Reference No:	2026/62/91551/E
Site Address:	Shepley Carr House, The Carr, Carr Lane, Shepley, Huddersfield, HD8 8BR
Description:	Erection of detached garage and garden room
Recommending Officer:	Nicole Helliwell

Officer Report

Proposal: Erection of detached garage and garden room

ELEVATION G

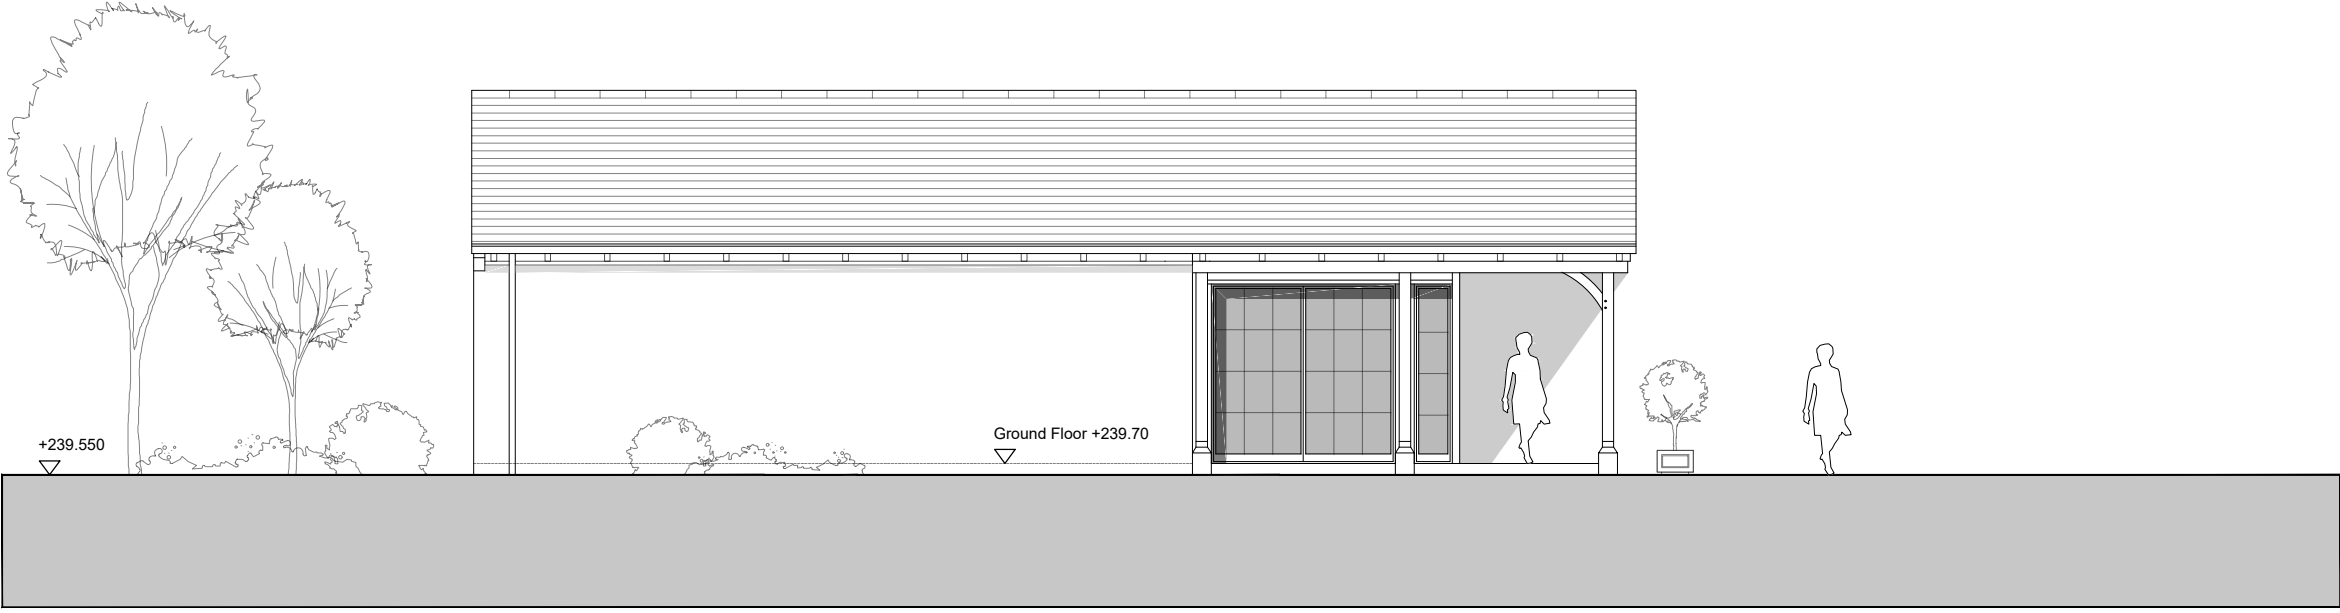
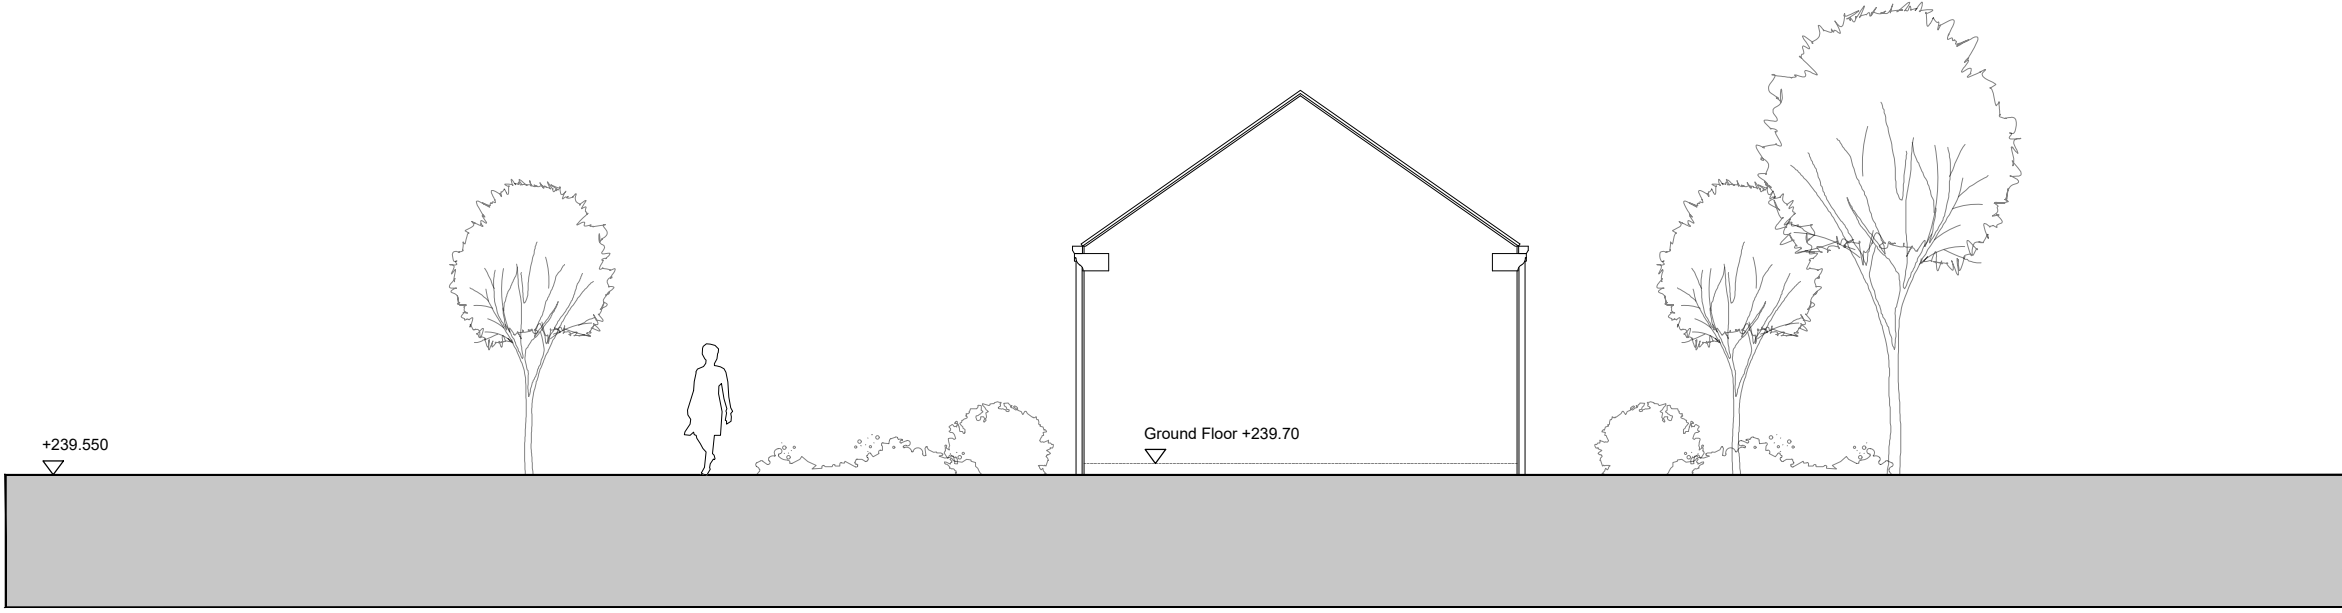
- The submitted architectural drawings are fundamentally deficient, lacking basic transparency and context.
- The elevations completely omit to illustrate the proposed detached Garage and Garden Room/Golf Simulator in direct visual relation to the host dwelling (Shepley Carr House). The structures are drawn in total isolation. Because the house is an irreplaceable heritage asset, the applicant has a strict duty to provide contextual elevations under Policy LP35 to demonstrate how the proposal preserves its setting.

- The drawings completely fail to state the proposed ridge heights, eaves heights, or exact structural dimensions for either the Garage or the Garden Room. Scale analysis of site plan drawing shows that the proposed Garden Room and Golf Simulator features an elongated footprint measuring approximately 14.5 metres in length by 4.5 metres in width, while the Garage measures approximately 10.5 metres in length by 5.5 metres in width. Without clear vertical dimensional data matching these large horizontal footprints, the council cannot mathematically evaluate the level of

overshadowing to neighbouring plots or the visual dominance on the heritage asset. The application remains technically un-assessable.

Officer Comments: *The drawings and details have been submitted in line with the Kirklees Planning Validation Requirements. Whilst the drawings do not state the measurements of the proposed development, the plans contain a metric scale and officers have been able to accurately assess the proposal.*
